### RE: Malsam Variance Application (VA-21-00005)- Deemed Incomplete

Parcel # 20344

Kittitas County Community Development Services received an Administrative Setback Variance request on April 12, 2021 to reduce the required 200-foot setback from the adjacent Commercial Forest Zone at the Northern Property Line. The subject property is zoned Rural Recreation. The parcel (20344) is located off **Breckenridge Drive** in Ronald, WA and bears Assessor's map number 21-14-34010-0025. Your application has been determined to be **incomplete** as of April 20, 2021.

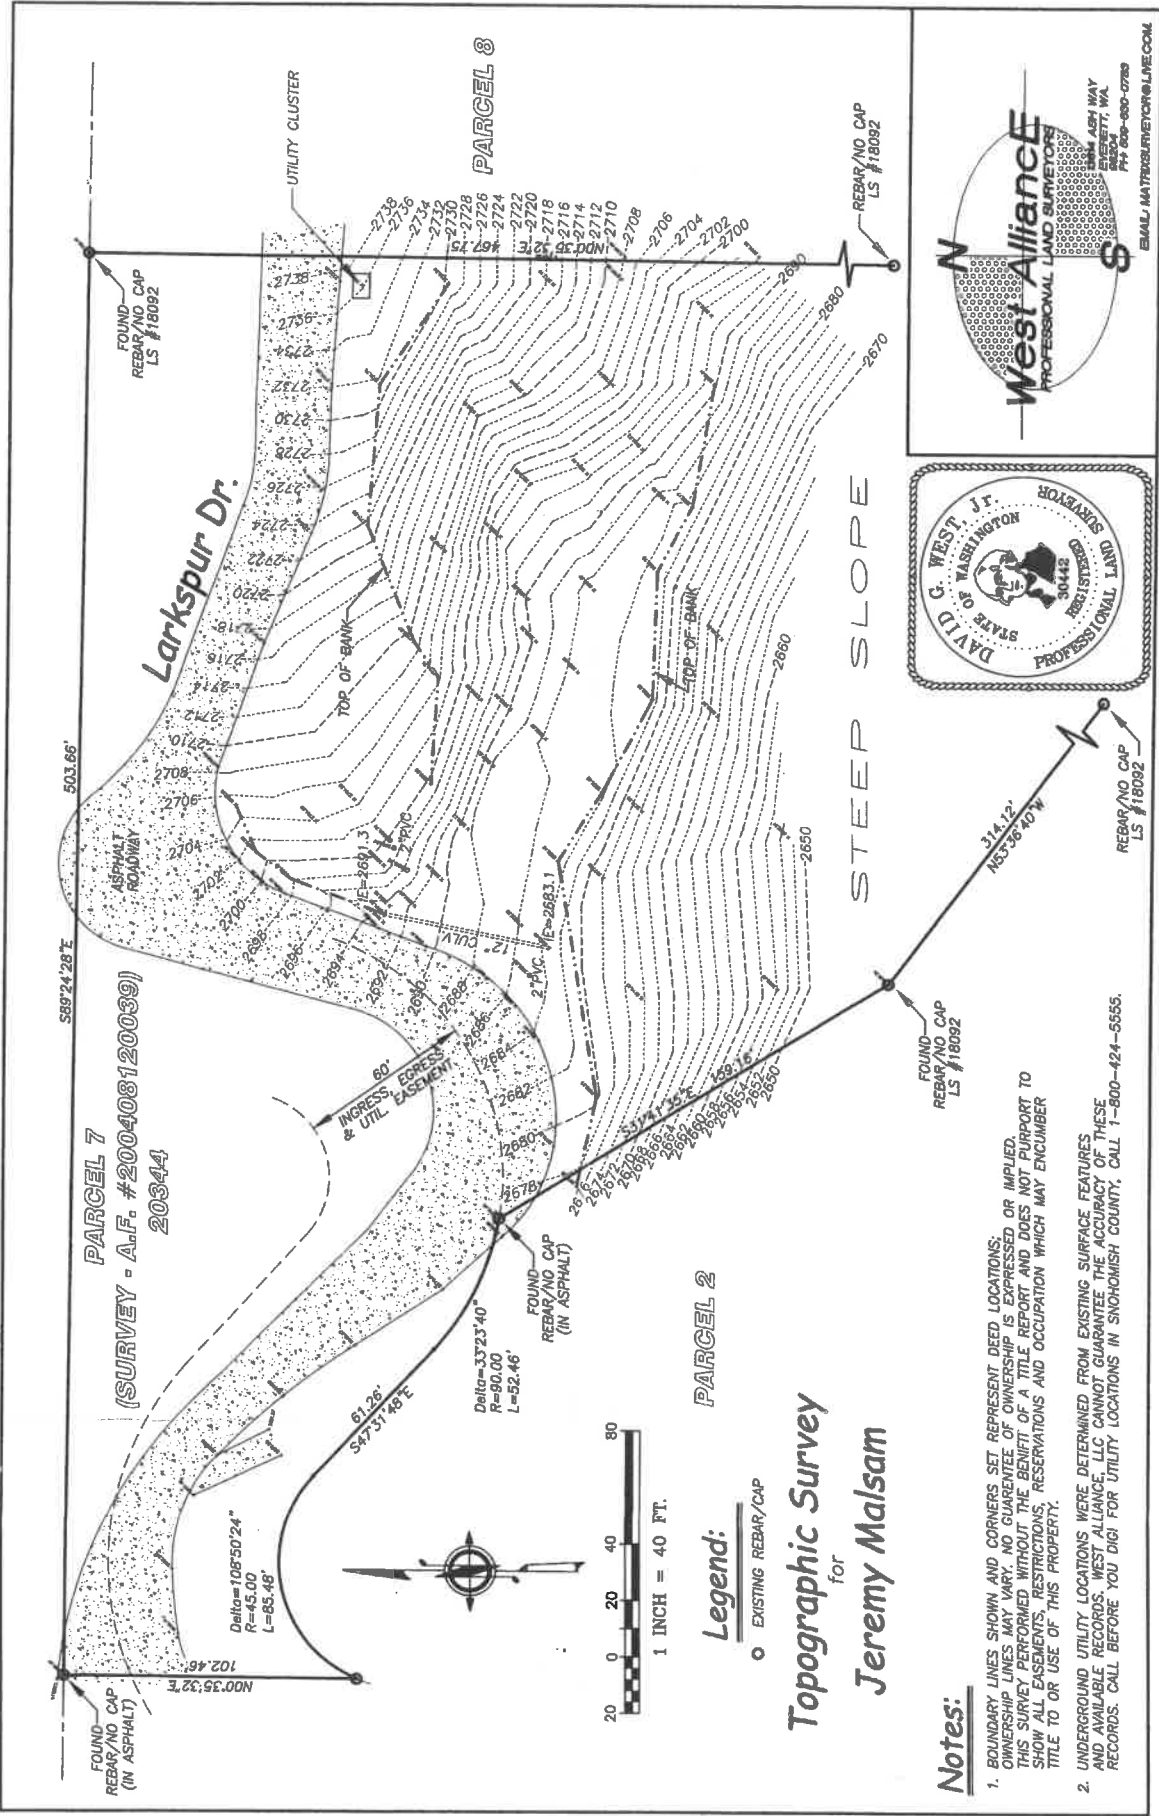
After a review of your application materials, it appears that there is not a clear request of how big of a variance you want from the 200-foot setback requirement. Preliminary measuring from your site plan shows that you would likely need to reduce the required setback from 200' to 80' since the covered patio is approximately 80 feet from the Northern Property line and is the furthest most North building according to your site plan. All other setbacks appear to be met on the submitted site plan. Also, it was not mentioned, but please put in your request that you wish to build outside of the 100 foot by 100-foot building envelope that is allowed per KCC 17.57.050.

Staff confirmed with public works that the road that would service this property is called Breckenridge Drive and not Larkspur Drive.

Please clarify your application for the setback you are requesting for the variance and update the site plan and application to have Breckenridge Drive instead of Larkspur Drive. Once we have these issues resolved, CDS will continue processing your application.
